Our Case Number: ACP-324584-26

Re: Proposed Limerick Wastewater Treatment Plant Upgrade & Regional Bioresource Centre
off Dock Road, Ballykeeffe, Corkanree and Courtbrack (townlands), Limerick

O.P.W Ref No. 227-2026

Re: Case Number: ACP-323900-25, Proposed upgrades to Limerick Wastewater Treatment Plant and Regional Bioresource Centre, Bunlicky, County Limerick.

CORCANREE PS
- EXISTING SITE LAYOUT PLAN

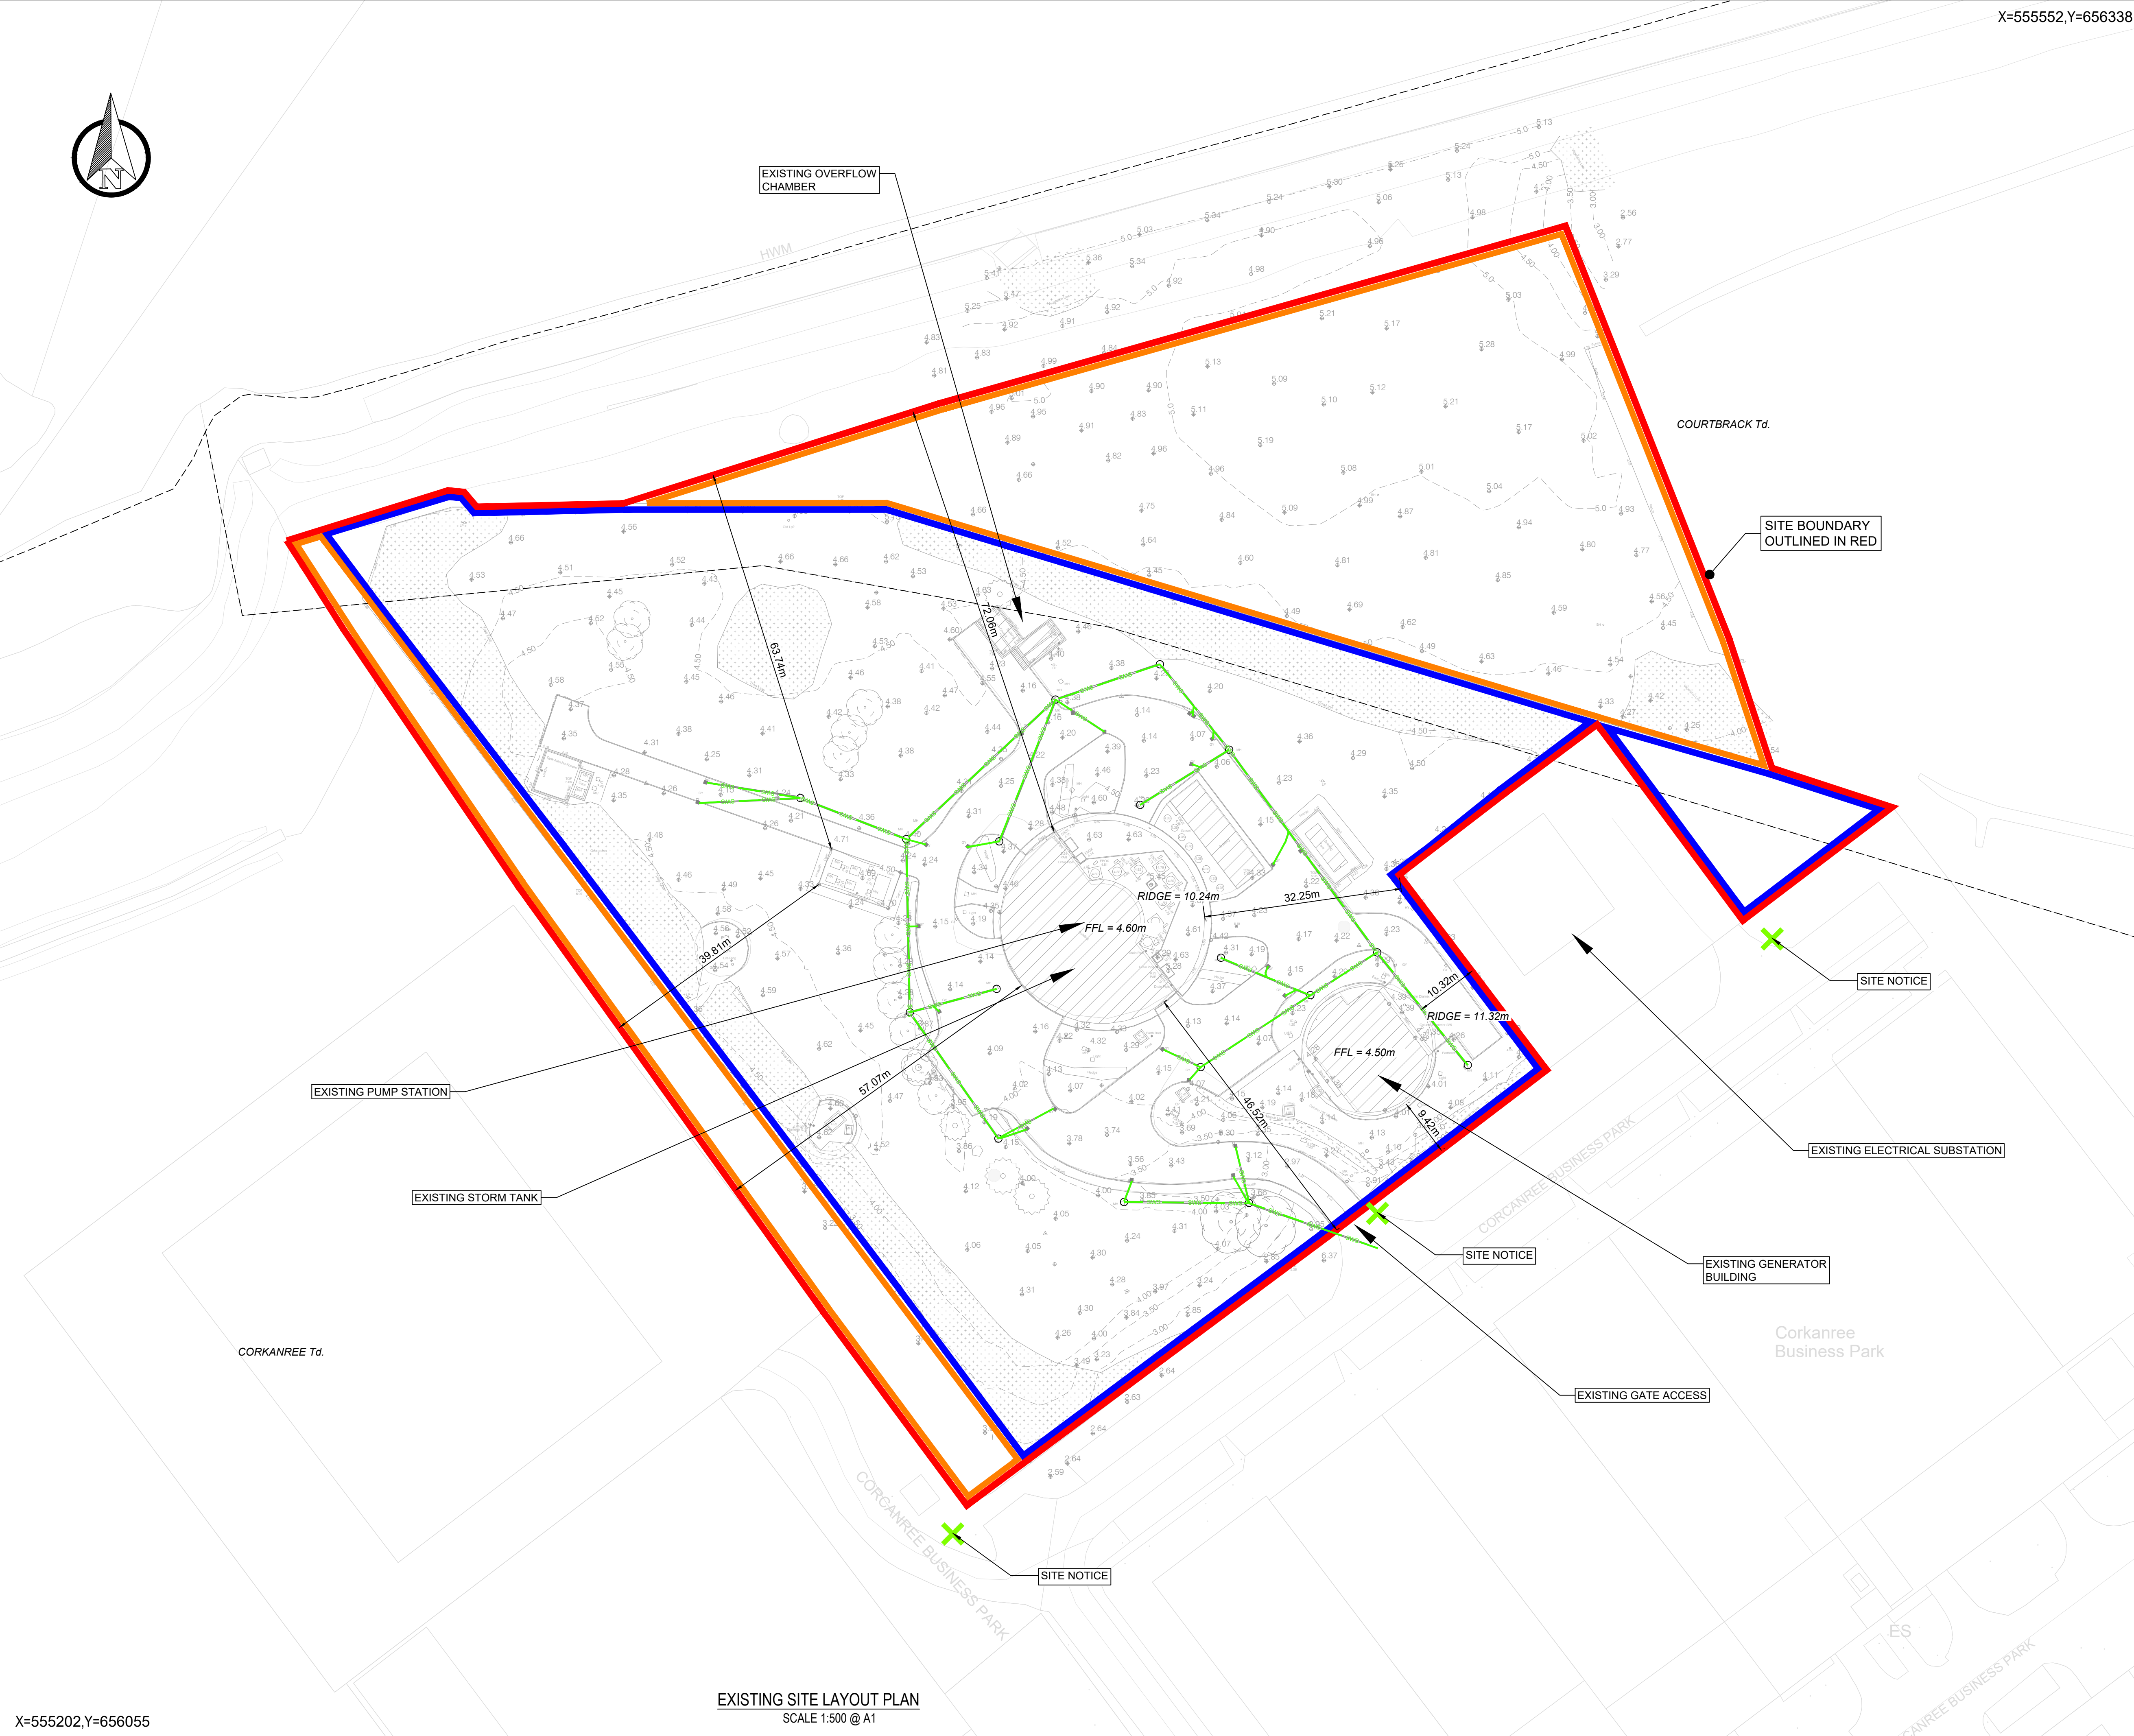
The site on Map A which contains Corcanree Pumping station is bounded on the Northern side by OPW Channel D1 of the Polefield Arterial Drainage Scheme which is under the auspices of this office. In order to gain access for the purpose of maintaining this channel, the Office of Public Works requests that the following be included as a Condition of any Grant of Planning Permission.

This office would request that a 5 Metres Wide strip be retained, adjacent to the channel D1 to facilitate on-going access and maintenance requirements. This strip should be unimpeded to mechanical plant and should not be landscaped, paved or otherwise developed in a manner that would impede or prevent access to said channel.

The Site of the proposed development, falls within the area deemed to benefit from drainage by Channel No. D1 of the Polefield Arterial Drainage Scheme and as a result is subject to an increased flood risk. The Polefield Arterial Drainage Scheme was originally constructed to a standard to protect agricultural land from flooding and as such does not confer the level of immunity usually associated with residential or commercial developments. Please find attached Map A, showing "Benefiting Land" shaded in green and D1 Polefield Arterial Drainage Scheme delineated in blue.
